WEST SUSSEX COUNTY COUNCIL CONSULTATION

TO:	Arun District Council FAO: Maria Tomalova
FROM:	WSCC - Highways Authority
DATE:	19 May 2021
LOCATION:	Land adjacent to Byfields, Nyton Road, Westergate, PO20 3US
SUBJECT:	AL/40/21/PL Construction of 1 No. 3 bed dwelling. This application is in CIL Zone 2 & is CIL liable as new dwelling.
DATE OF SITE VISIT:	N/A
RECOMMENDATION:	Advice
S106 CONTRIBUTION TOTAL:	N/A

PLANS

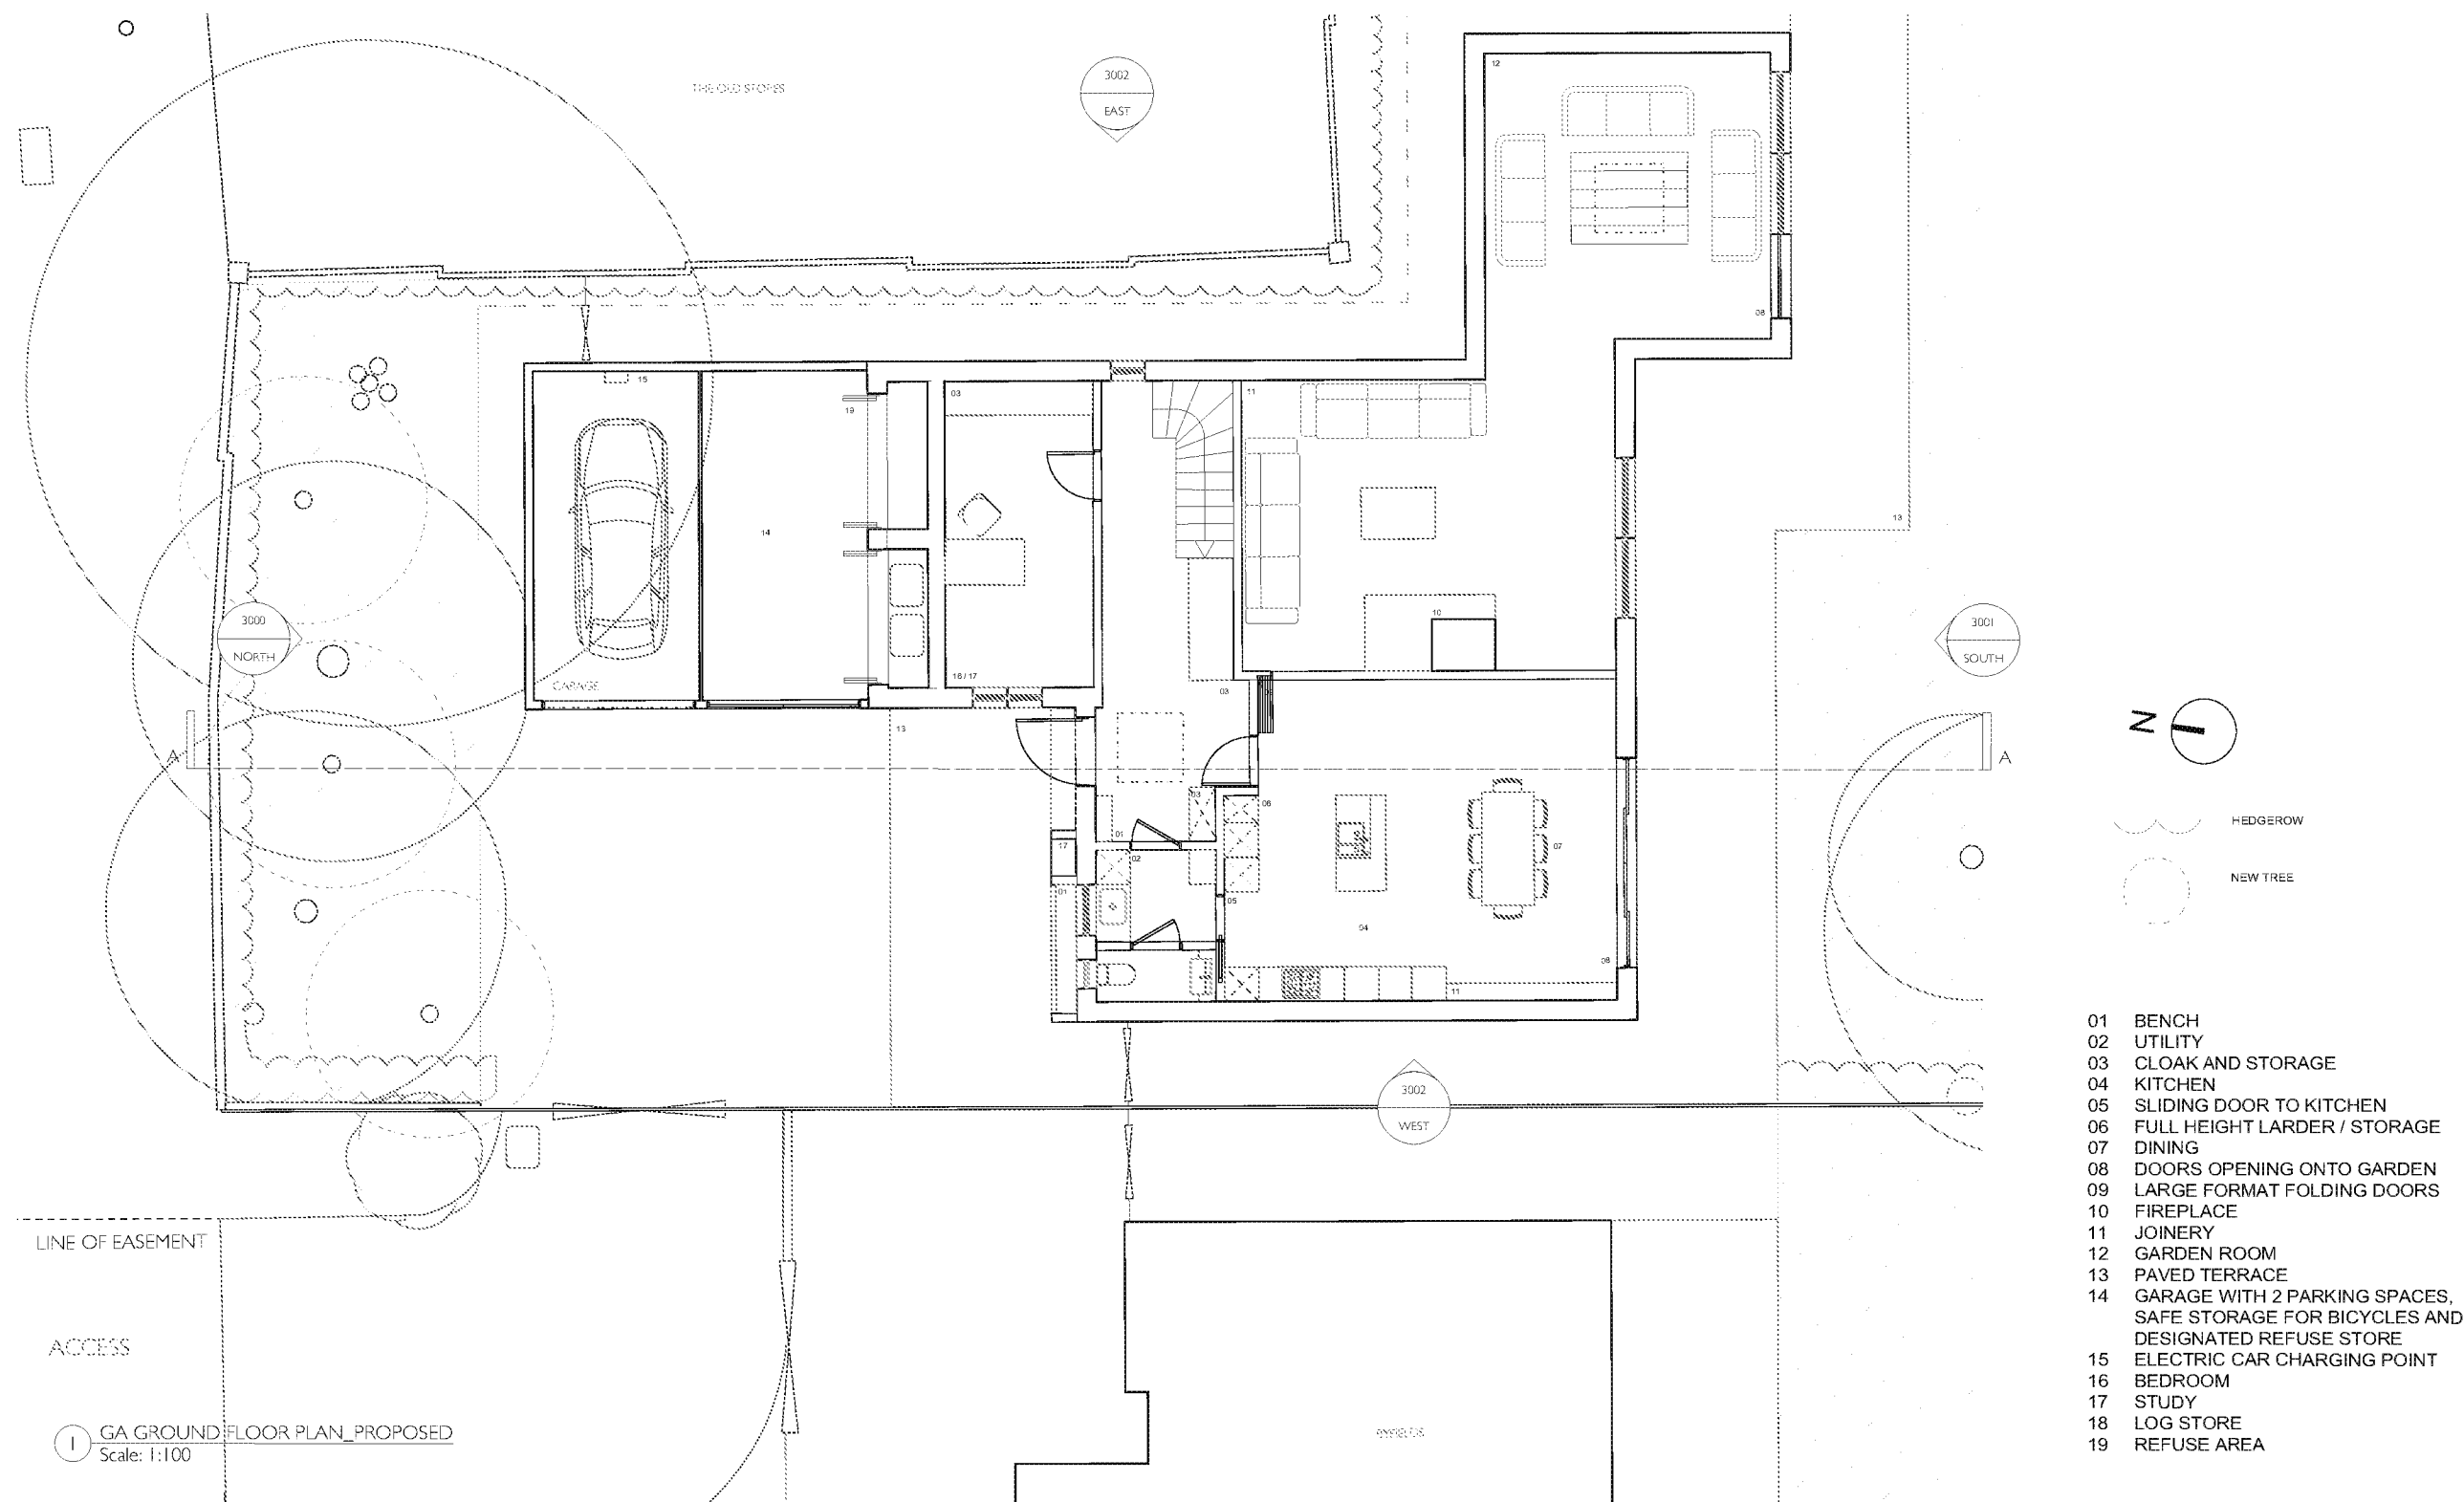
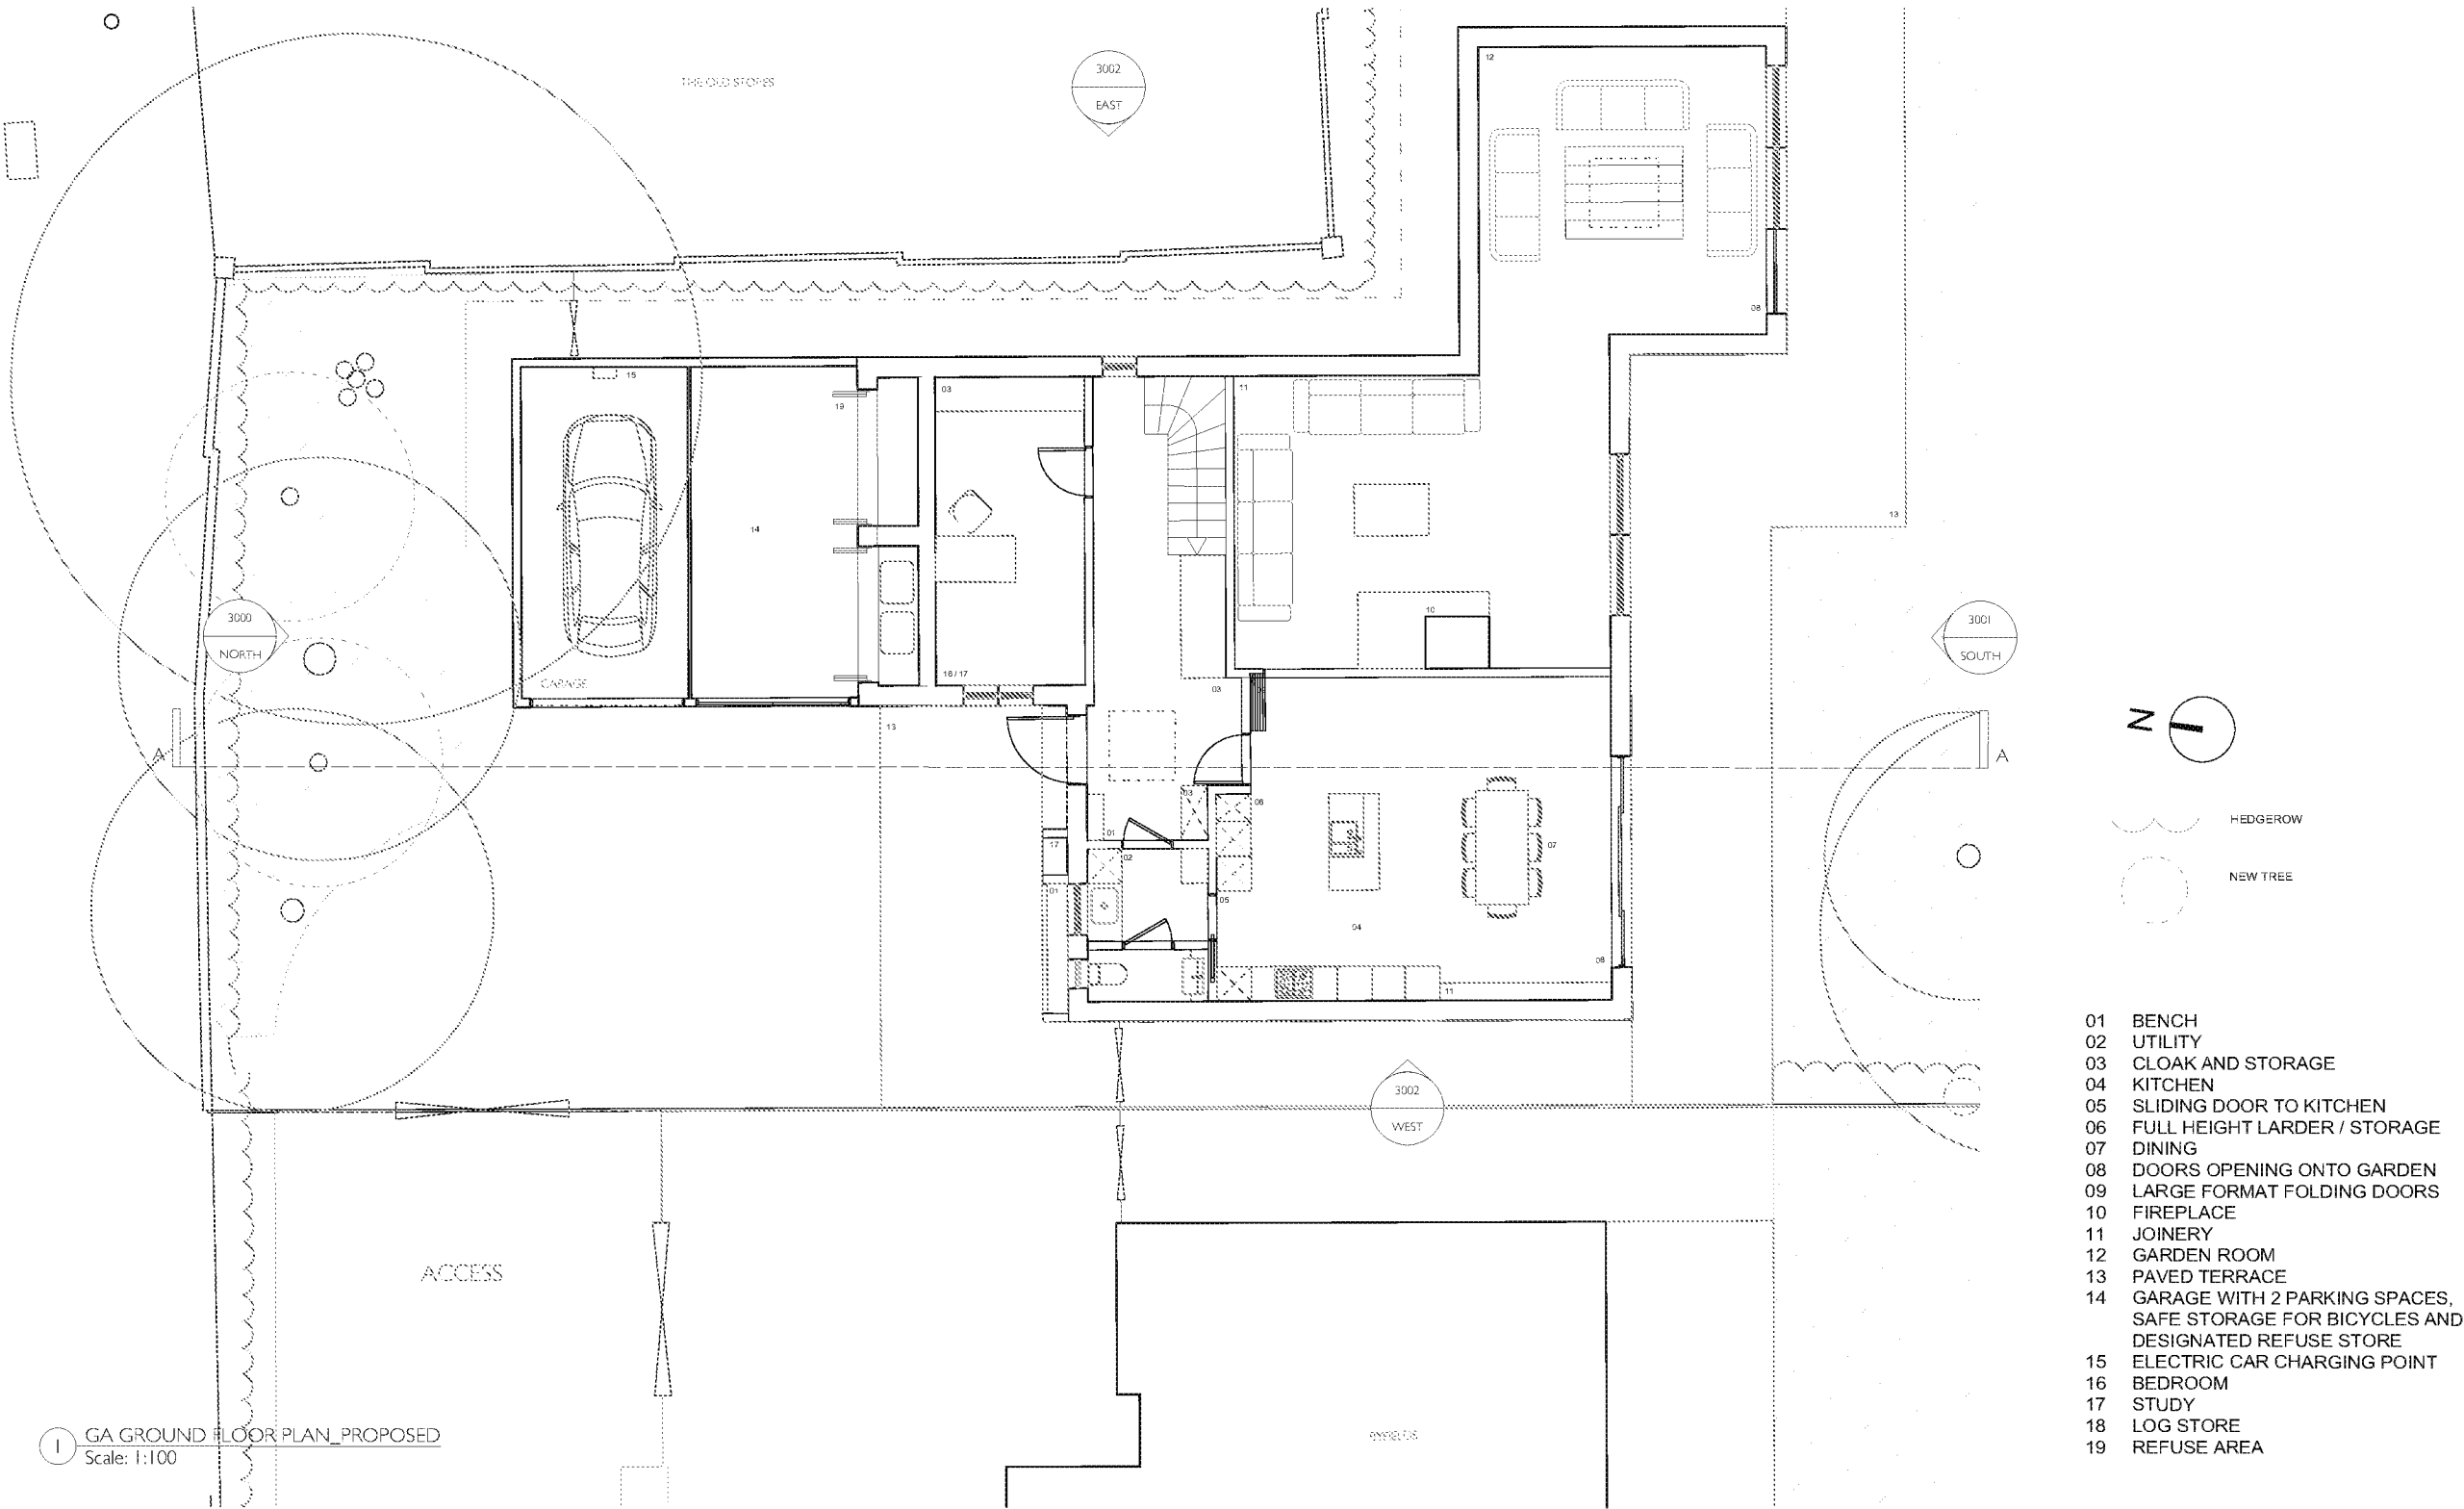
The applicant proposes two car parking spaces for this development, in the form of a double-car garage. Additional space is provided in front of the garage, providing room for additional parking and turning space. Under Arun Parking Standards, the LHA would expect a dwelling of this size in this location to provide at least two car parking spaces. Therefore, the LHA considers the proposed parking provision to be sufficient.

The LHA does note that the proposed garage falls slightly short of the minimum internal specifications for double-car garages of 6m x 6m as set out in Manual for Streets. The garage as proposed has approximate internal dimensions of 5.8m x 5.7m. Therefore, the LHA cannot consider the garages for vehicular/cycle parking provision. The LHA advises the applicant to enlarge the garage to meet MfS specifications. Notwithstanding this, the LHA is satisfied that sufficient parking provision is available on-site.

The applicant has not demonstrated cycle parking, and the LHA would like to see cycle parking being implemented in accordance with Arun Parking Standards. As mentioned above, if the applicant enlarges the garage to meet MfS specifications, the LHA can consider it for cycle parking provision. The inclusion of secure and covered cycle parking helps promote the use of sustainable transport methods.
